From: Nicola Spencer
Sent: 20 December 2019 10:37
To: 'chris barrow'
Subject: RE: 27 shrubbs drive. PO22 7SW

GROUND FLOOR PLAN
[1:50]

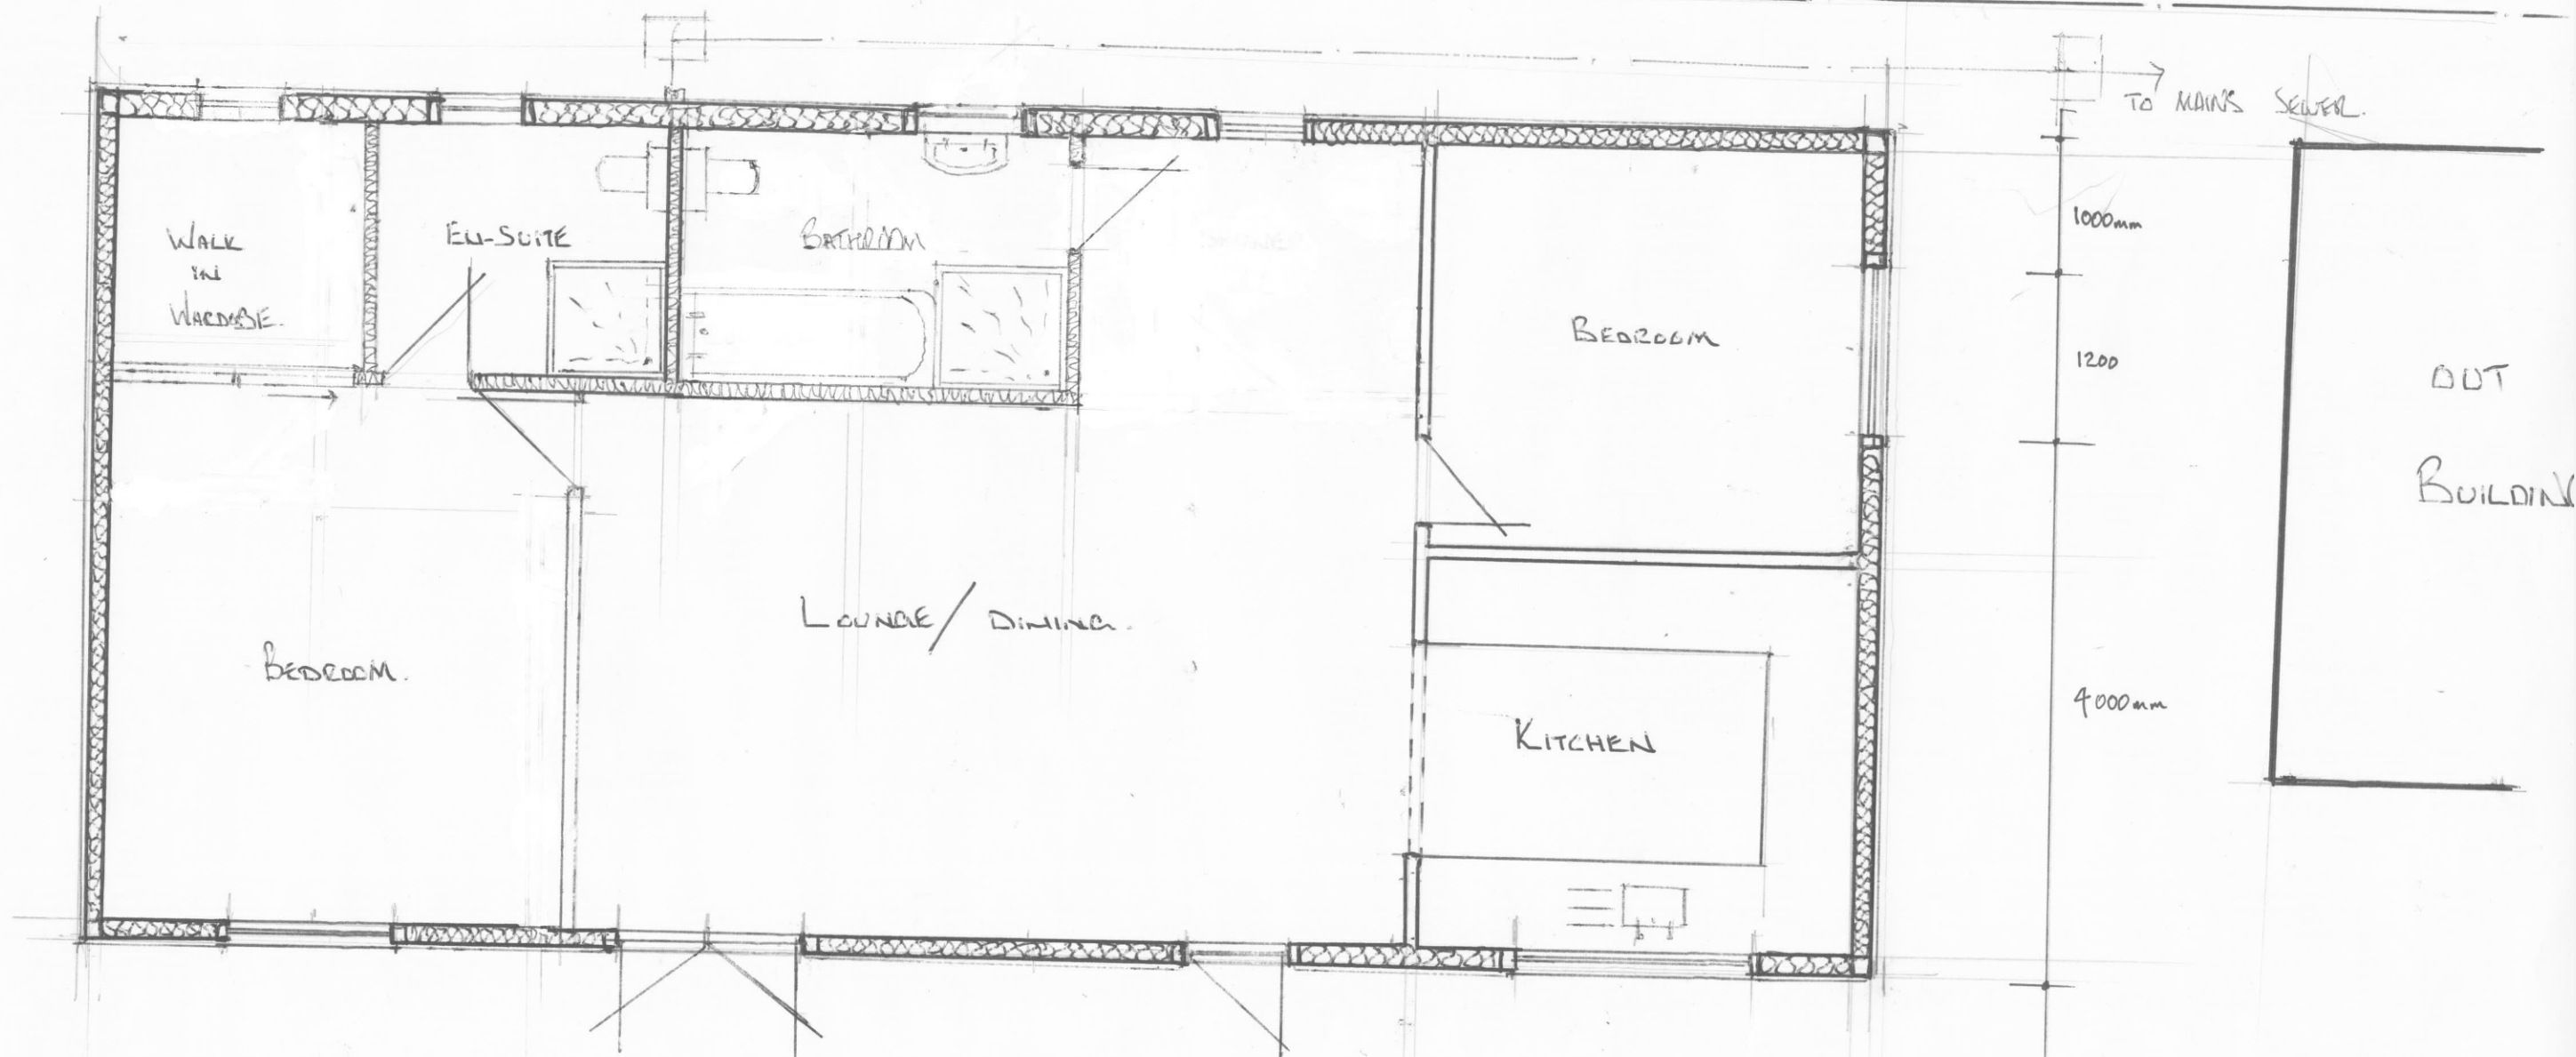
No the drawing still does not scale but in case I have been contacted by your client to advise that you are no longer acting on their behalf, I would be grateful if you would confirm that this application can be withdrawn.
